RE: MARTIN PLACE STATION PRECINCT STAGE 2 – NORTH SITE (SSD 9270)

On 8 October 2018, the Department of Planning and Environment requested the Government Architect NSW (GANSW) provide an independent design review of Martin Place Station Precinct Stage 2 – North Site (SSD 9270). In conducting the review, GANSW has considered the EIS prepared by Ethos Urban, dated 4 October 2018, and its appendices, as well as the advice previously provided to the proponent through the Martin Place Over Station Development (OSD) Design Review Panel (DRP) which is chaired by GANSW.

Figure 1. Elevation - Hunter Street edge

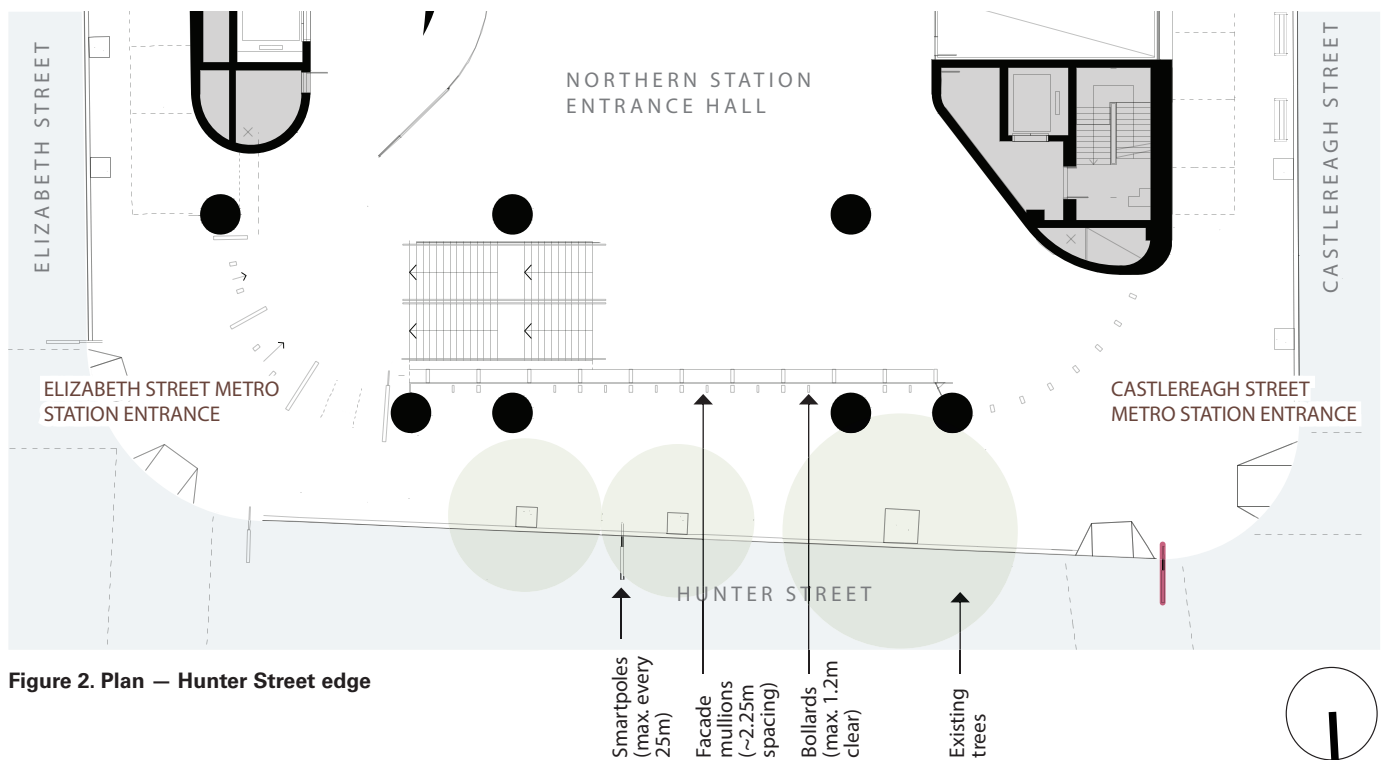
The building's interface with Hunter Street is unresolved. We remain concerned about the spaces between the building and columns on the northern elevation.
